# CITY OF ALBUQUERQUE

## Letter of Advice

Project: PR-2018-001284

Date: July 11, 2018

**Sketch Plat for  
Tracts A-2-A-1-A &  
A-2-A-2-A, Park Square  
Being Comprised of  
Tracts A-2-A-1 & A-2-A-2  
Park Square  
City of Albuquerque  
Bernalillo County, New Mexico  
July 2018**

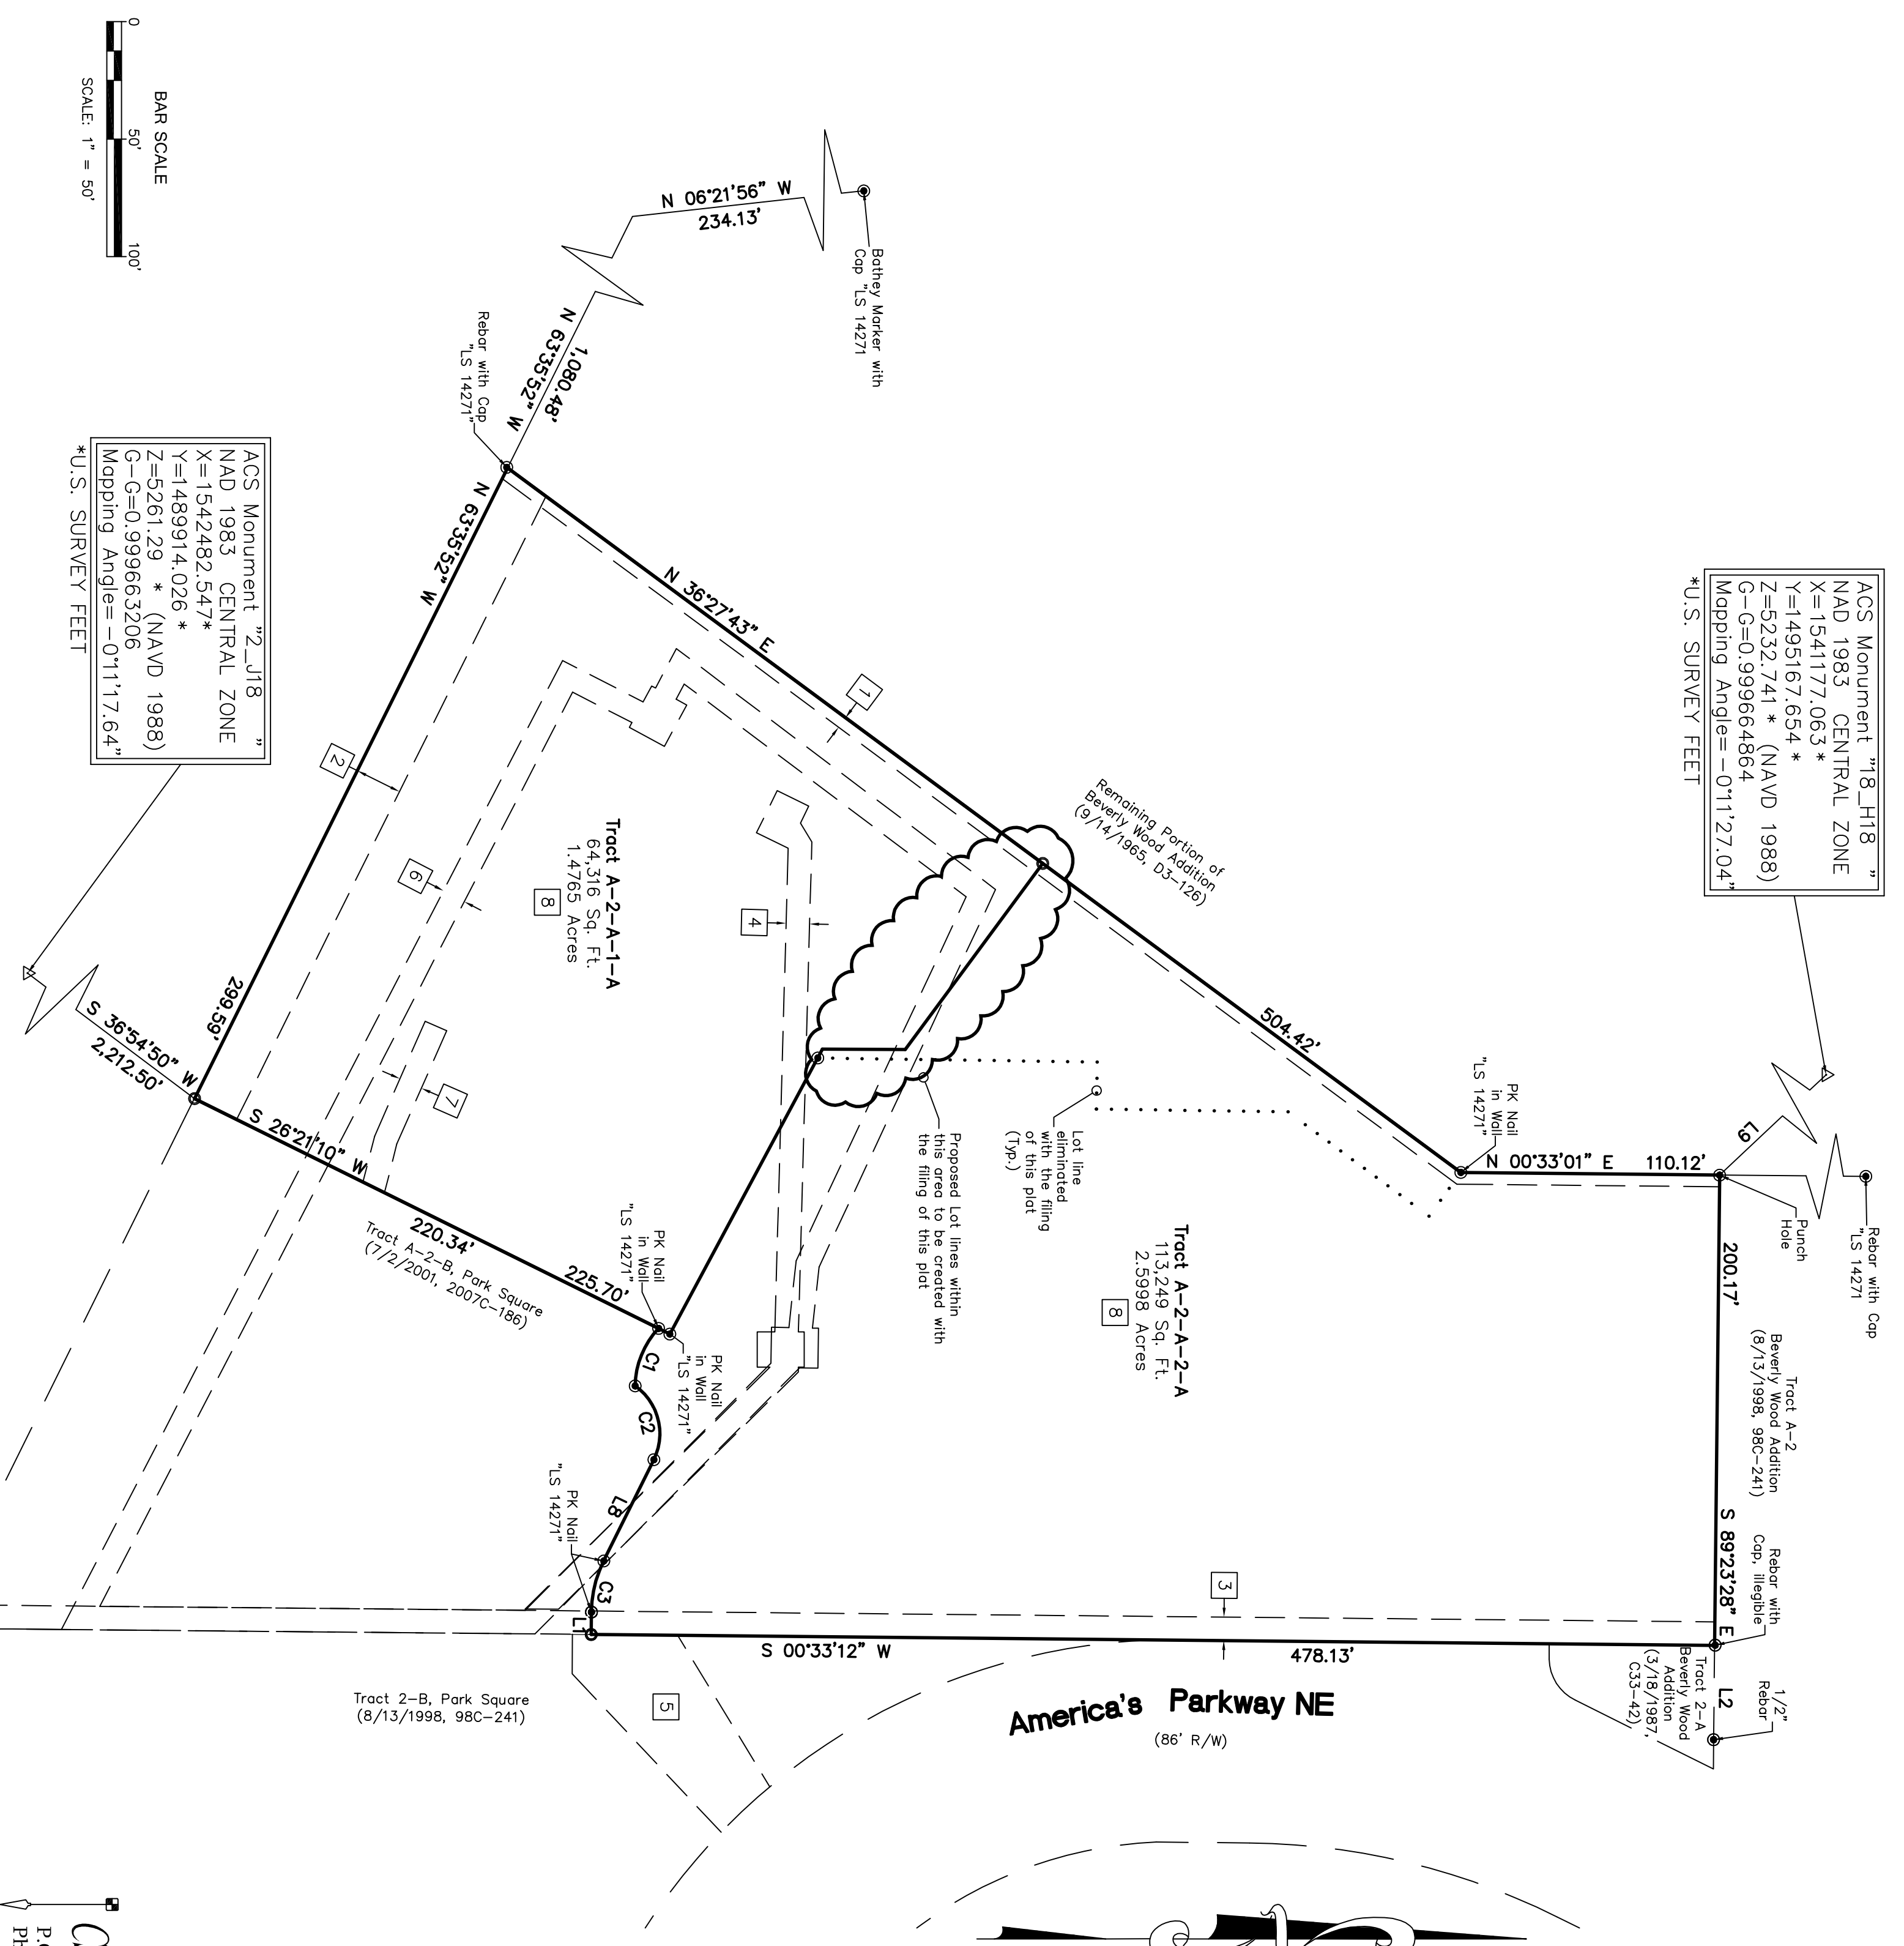
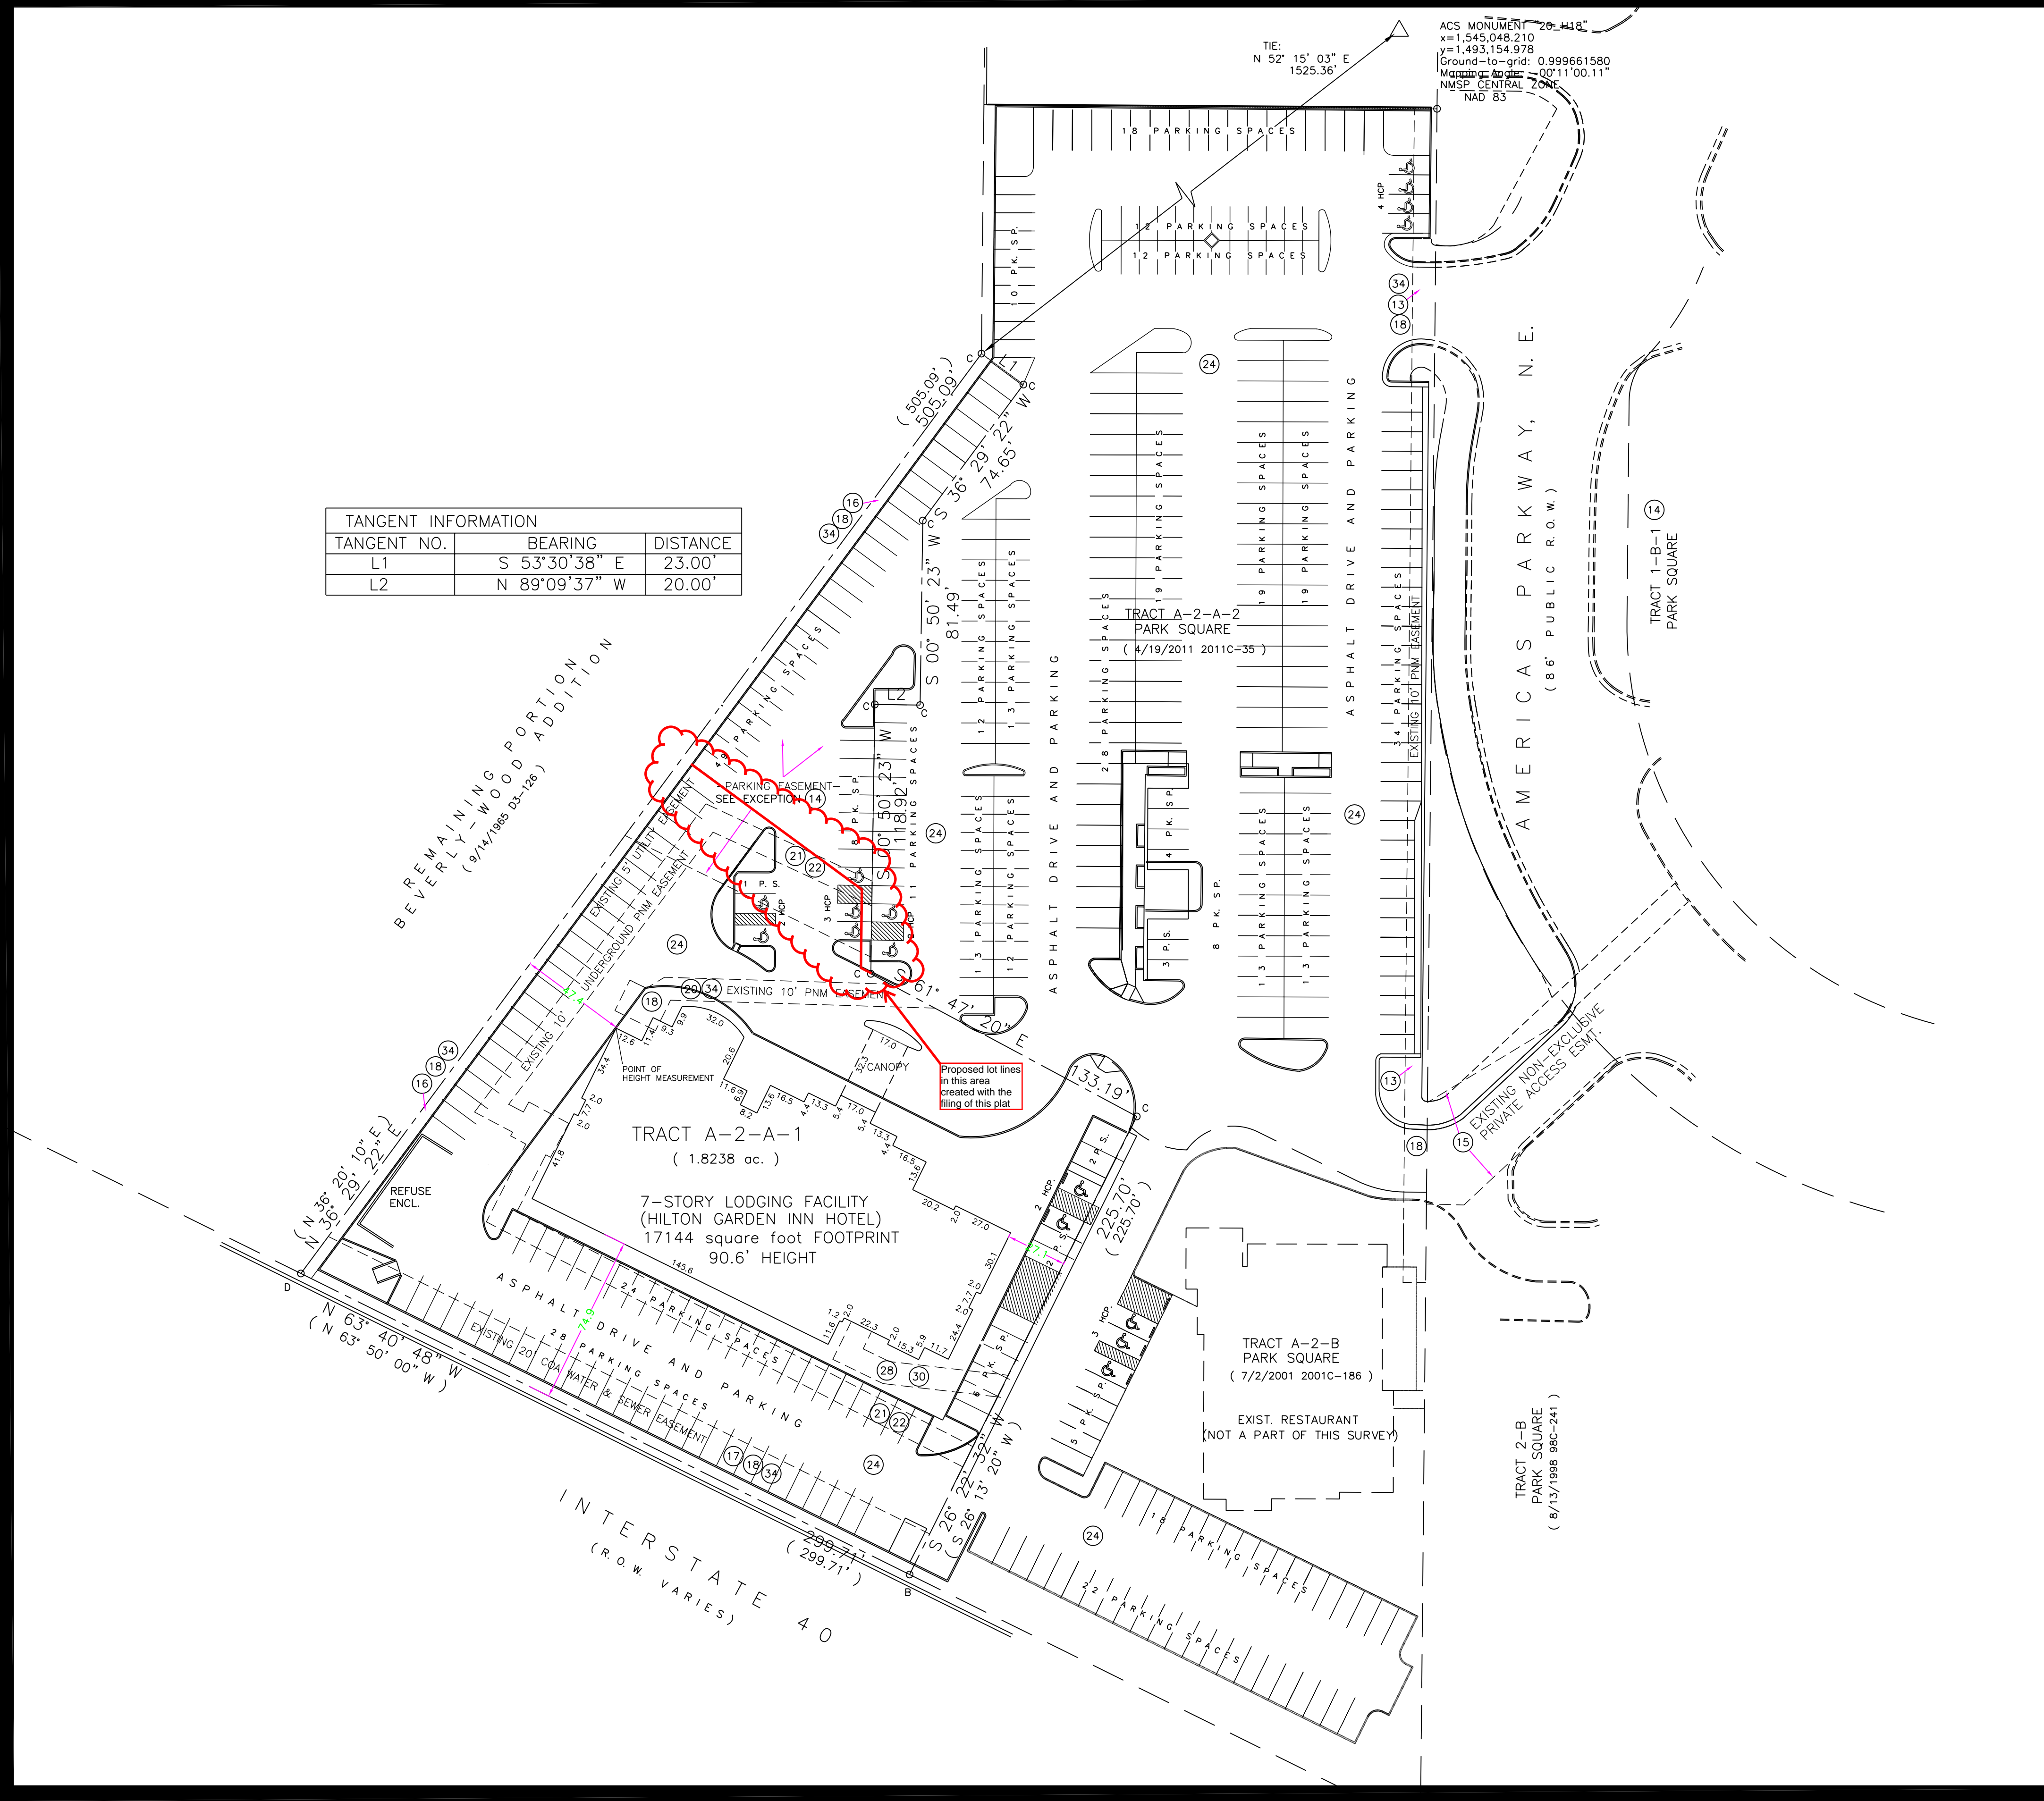
1. Provide a sidewalk exhibit showing the location, width, and defining the distance from back of curb to the property line. Right of way dedication may be required.
2. If future development is not going to be submitted to DRB, a TCL (Traffic Circulation Layout) will be required before building permit.
3. For final plat, any access easements need to be shown with all beneficiaries and maintenance responsibilities listed.
4. Please include a copy of your shared access agreement with the adjacent property owner.
5. Parking spaces cannot be split by lot lines.

- No objection lot line adjustment.
- The Grading and Drainage plan must be revised to show the new lot line prior to any land development activities.
- Cross lot drainage easements are required prior to Hydrology approval of this plat.

- 
- Circled note 13 is shown on the plat but the actual note states that 13 was intentionally omitted?
  - What does note 6 under Surveyor's Notes mean? Setbacks are either set by site plan or code?
  - No adverse comments to the new lot lines.
